ExQ3	Question to:	Question:	East Suffolk Council Response:
DCO.3 Draft Development Consent Order (DCO)			
DCO.3.0	The Applicant	In the redrafting of the CoCP for D7, has the substance of any of the commitments been changed? To take an example, in Part C, section 8 (Historic Environment) the whole of section 8.2 has been deleted and a new para 8.1.4 inserted. It seems to the ExA that the effect of 8.2 is now contained in para 8.1.4. Is this the intention and effect?	
DCO.3.1	The Applicant	(a) At para 1(4) of Sch 2 (reqts) of the dDCO Revision 8 the Applicant has deleted the word “substantively” from “substantively consistent” and also deleted the words “and in a manner that does not give rise to any materially new or materially different environmental effects to those assessed in the environmental information”. Please will the Applicant explain the reason for the latter deletion. Is it inevitable that works to be carried out in general accordance with details etc will, if they are simply consistent with those details etc not give rise to materially new / different effects? (b) However, the ExA is finding it more difficult to understand the Applicant’s reluctance to abandon the use o

REVISION:
03

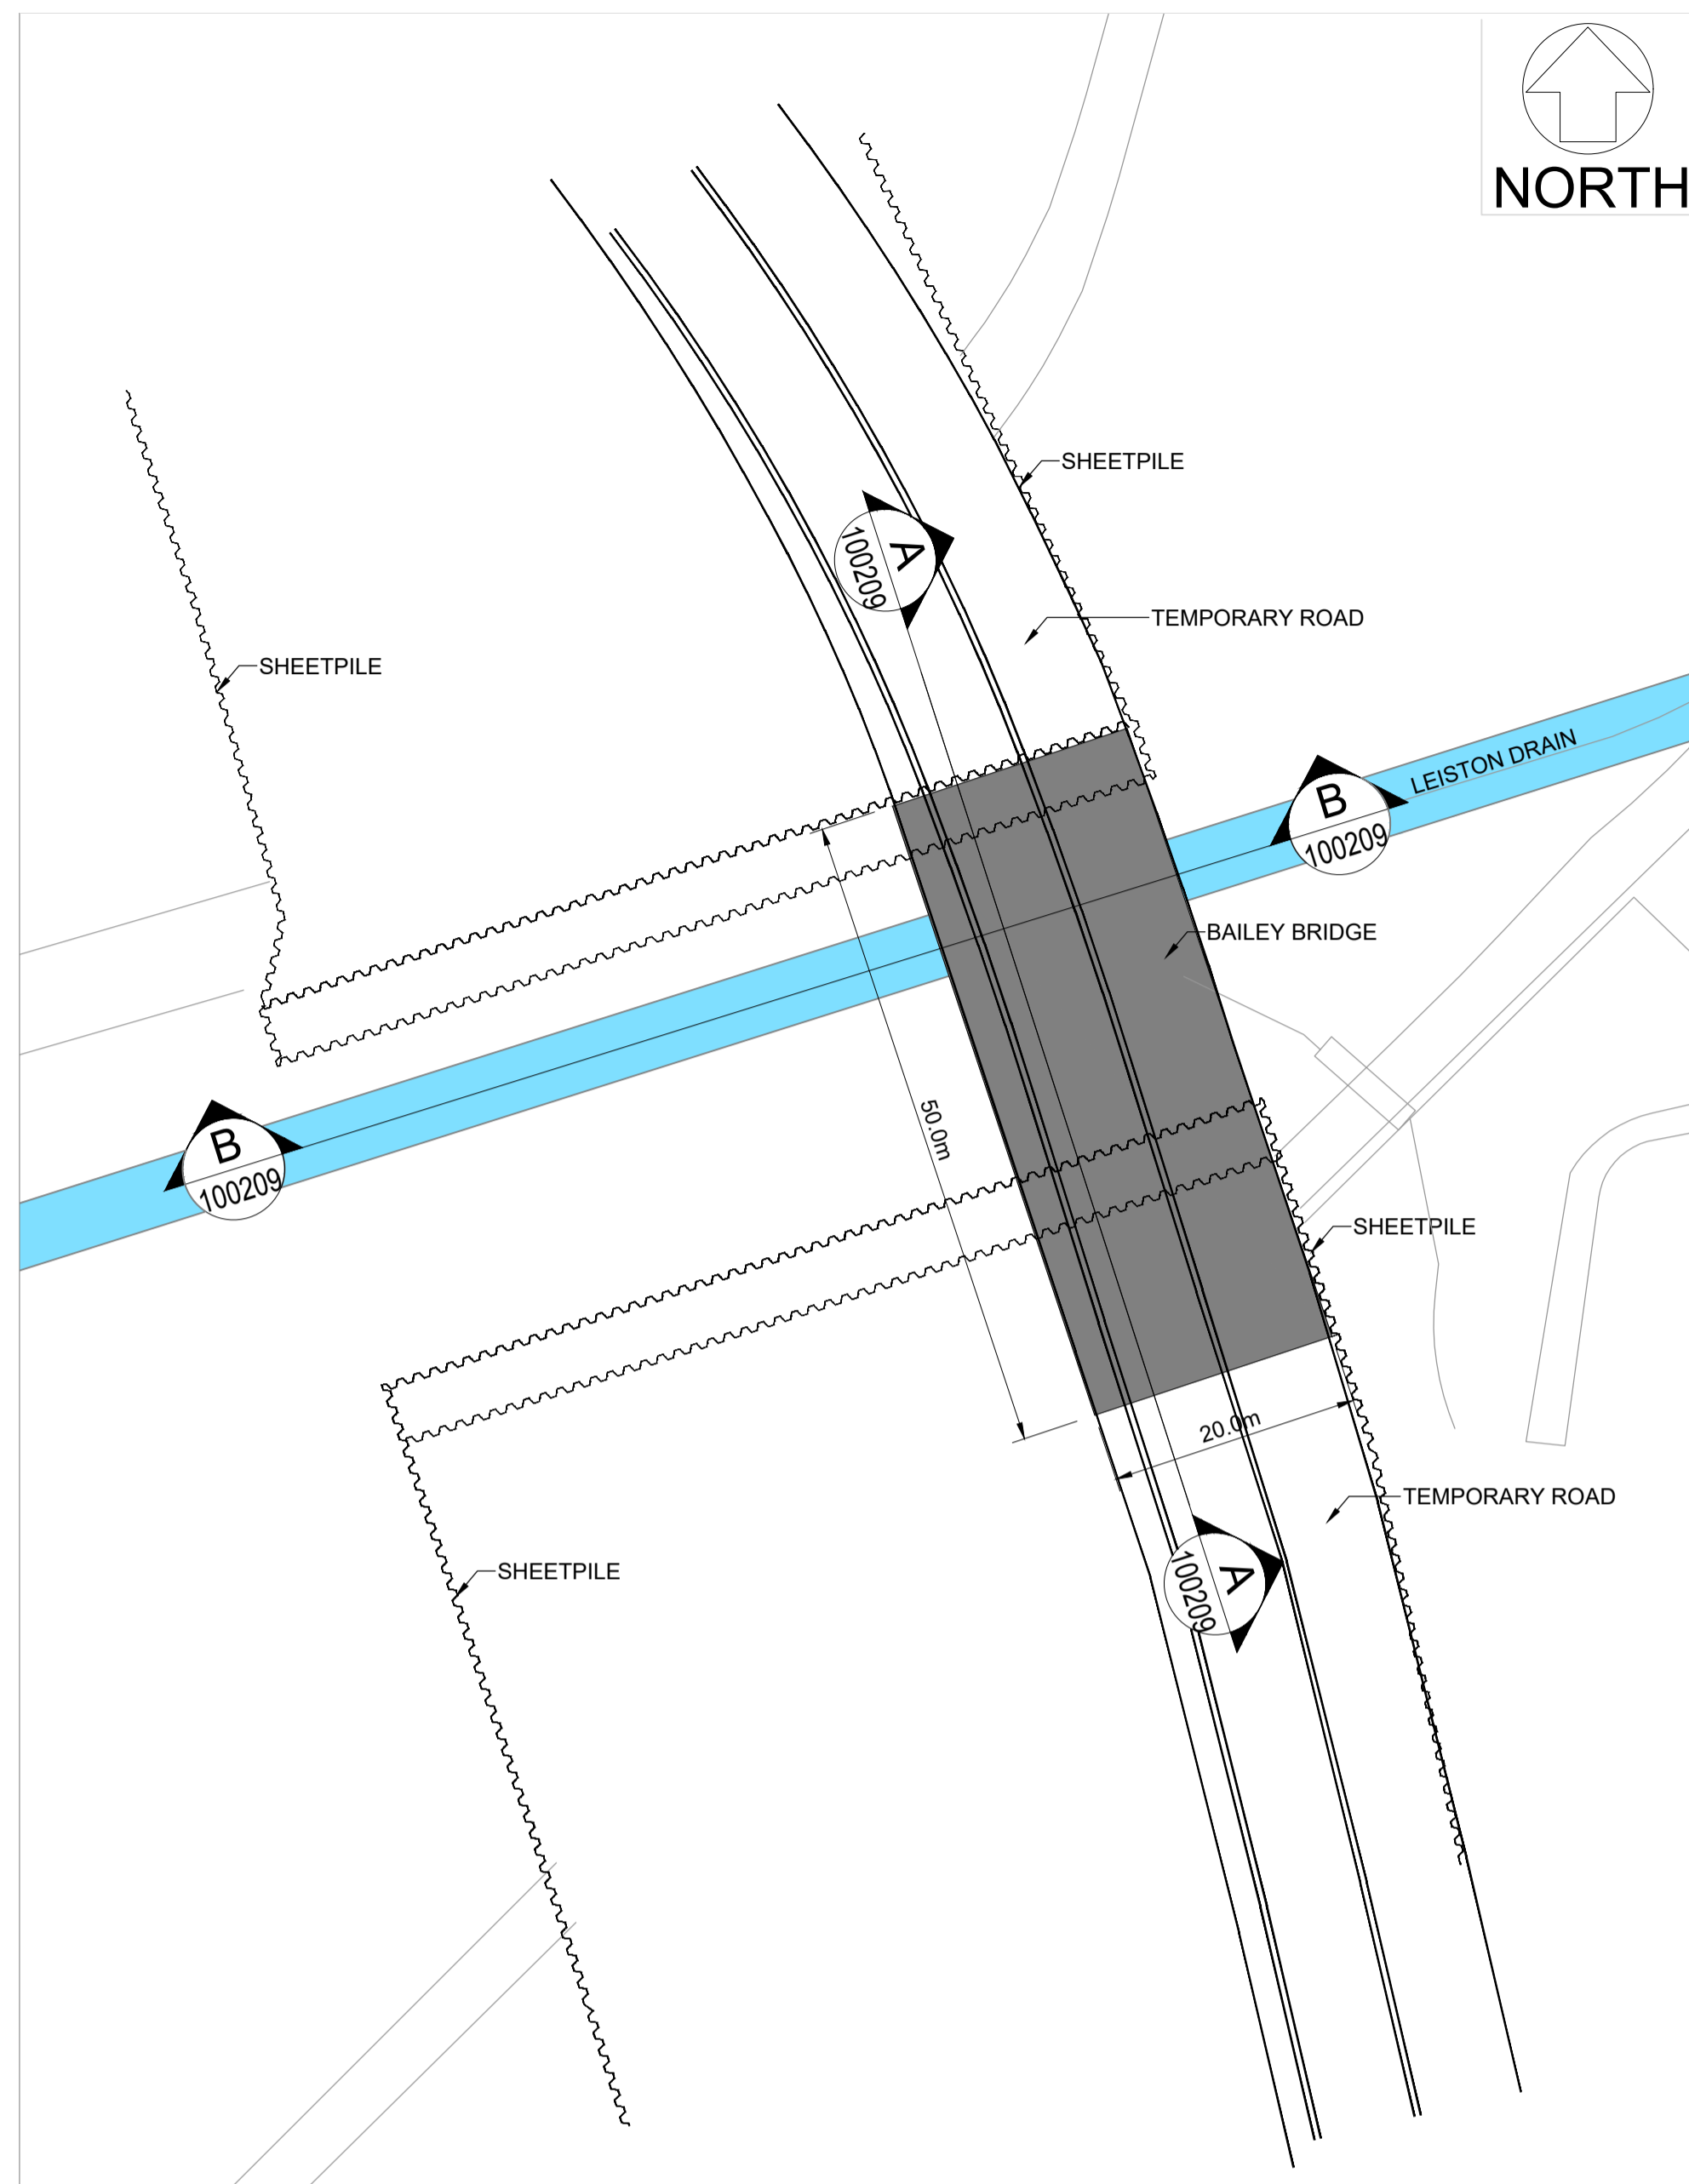
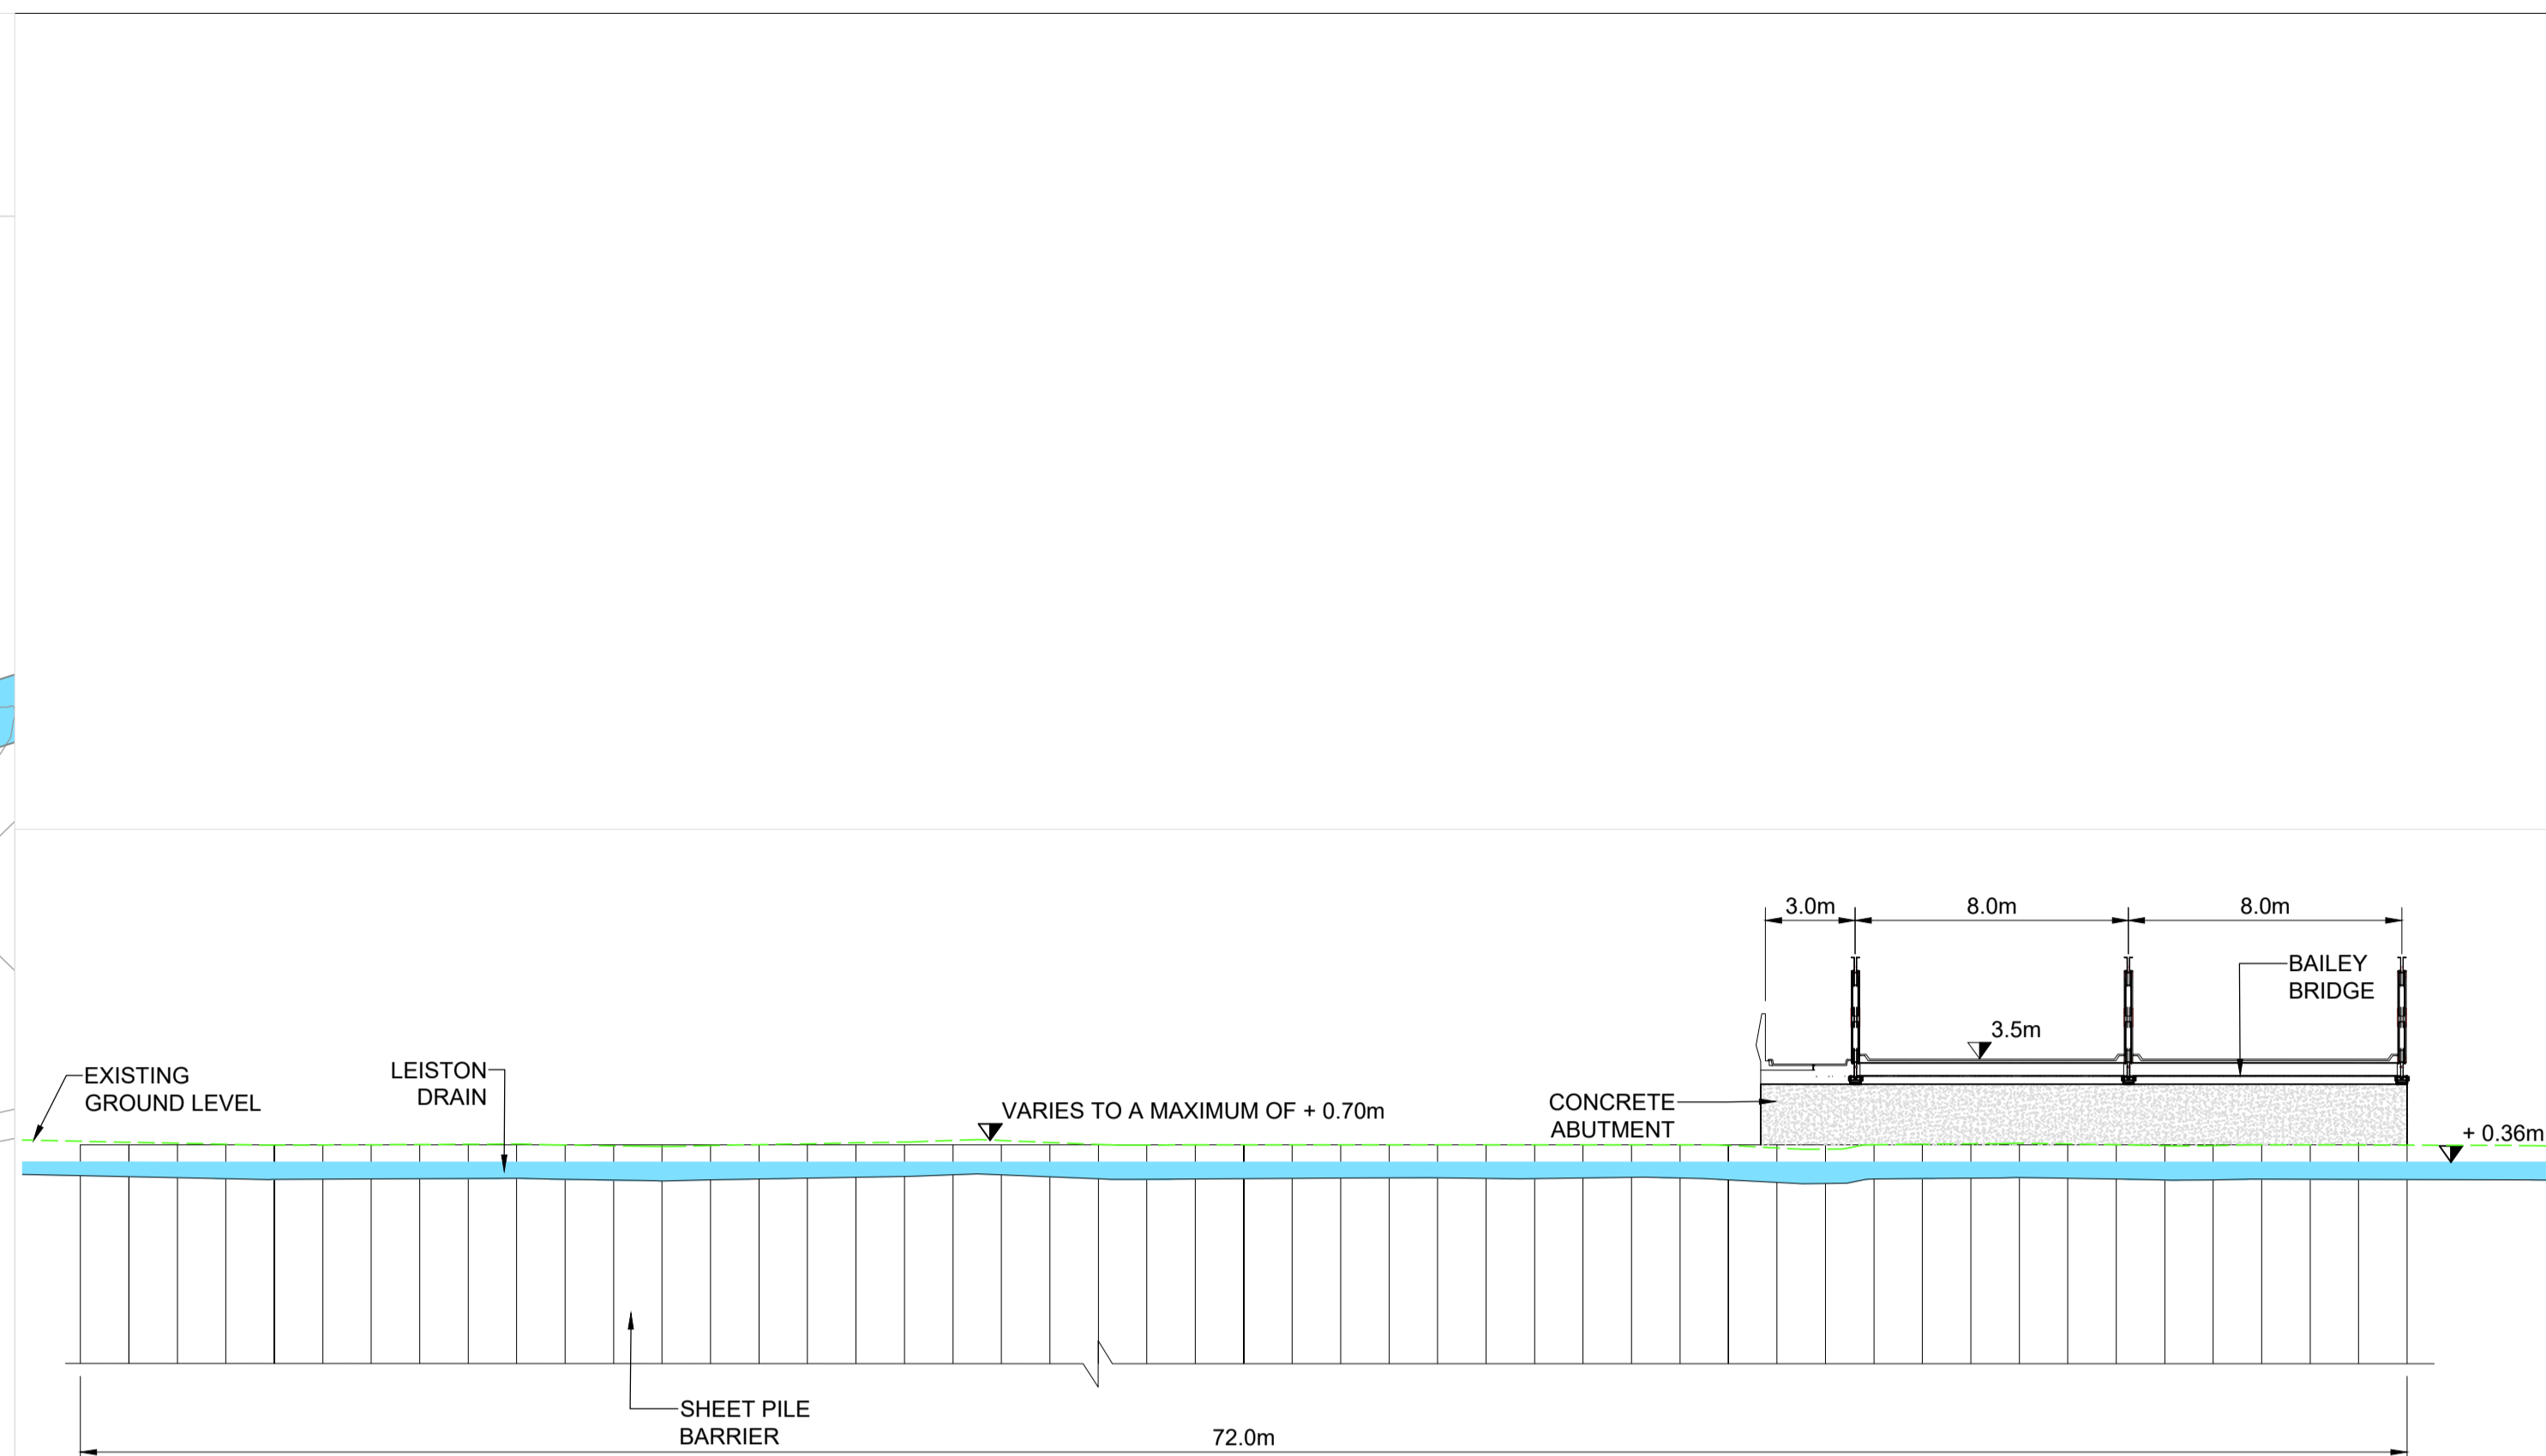
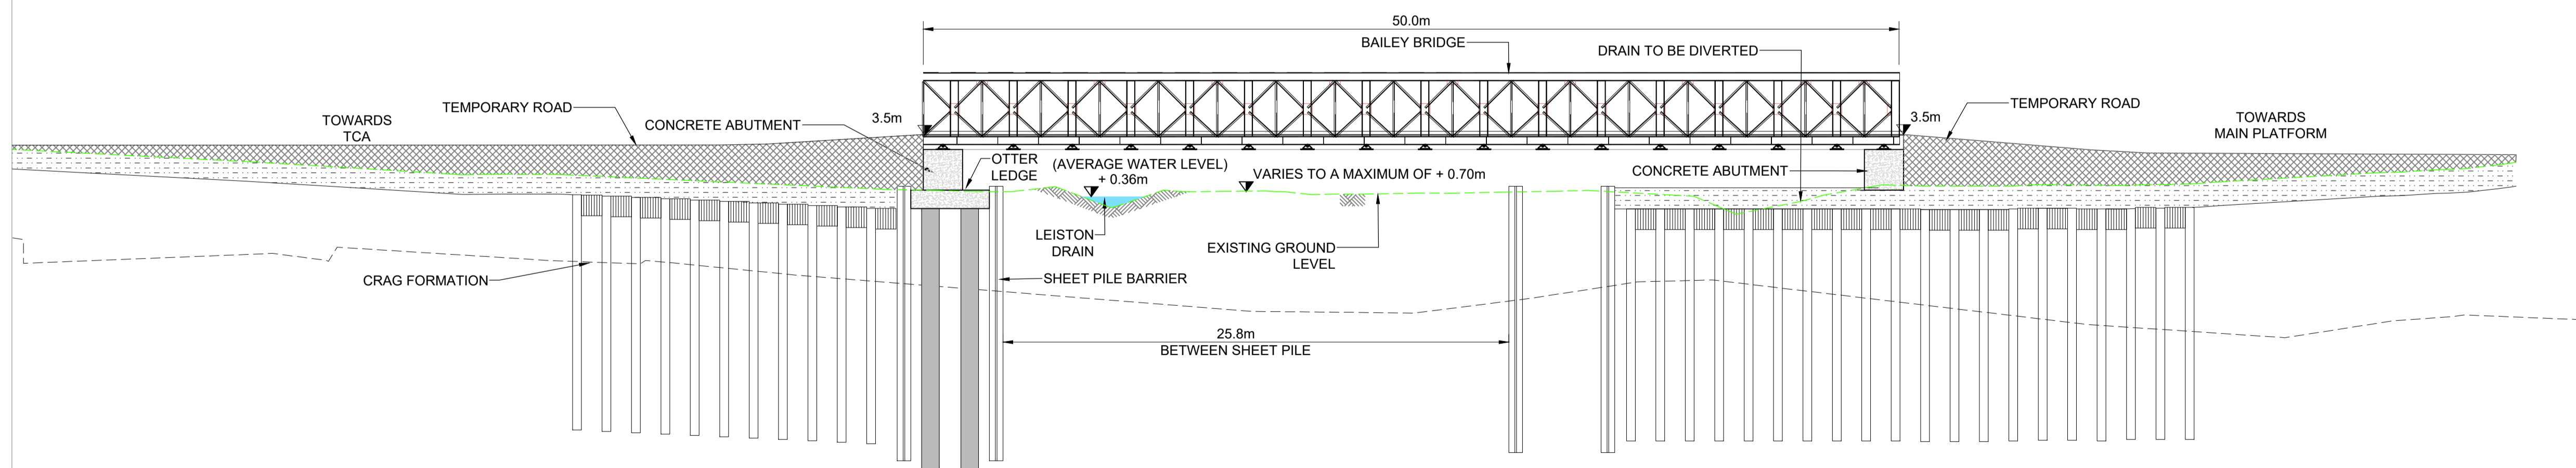
LI.3.4	Applicant	SSSI Crossing The content of Principle 79 of the Detailed Built Development Principles [REP5-070] is noted. However please further expand on how the colour selection of the hard elements of the SSSI crossing, visible from public viewpoints, has taken into consideration the advice contained in 'Guidance on the Selection and use of Colour in Development' published by the Suffolk Coast and Heaths AONB?	
LI.3.5	Applicant	Main Development Site –
